The scale of the proposed solar farm is vast and would encompass the majority of Frodsham marsh. Many residents have major concerns regarding the loss of so much green belt and its impact on the landscape. There are several positive aspects to the planned development. i.e.

Chris Copeman Ward Councillor for Helsby, Cheshire West and Chester Council

**Image 4.1 - Indicative Construction Traffic Routing Plan**

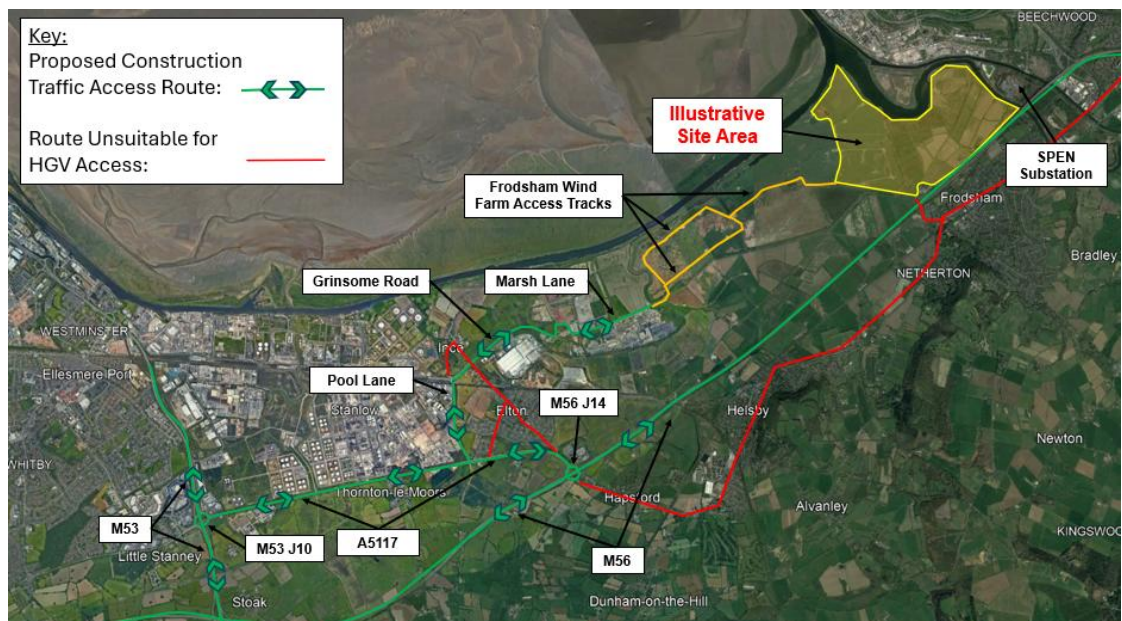
The vast scale of the project will undoubtedly require hundreds of heavy vehicles travelling down the designated access route from Ince along Lordship Lane to the construction site. This will have a significant impact on cyclists and pedestrians being able to use the route safely which would deter active travel.

Cubico should be asked to explore the delivery of all construction materials to a pier on the Manchester ship canal by Frodsham marsh farm.

If this is not possible all deliveries should be made outside the normal working day to enable active travel to continue safely on Lordship Lane and reduce the pressure on both the frequently overloaded M56 and Ince village

Cubico should be responsible for returning this lane to better than its original condition.
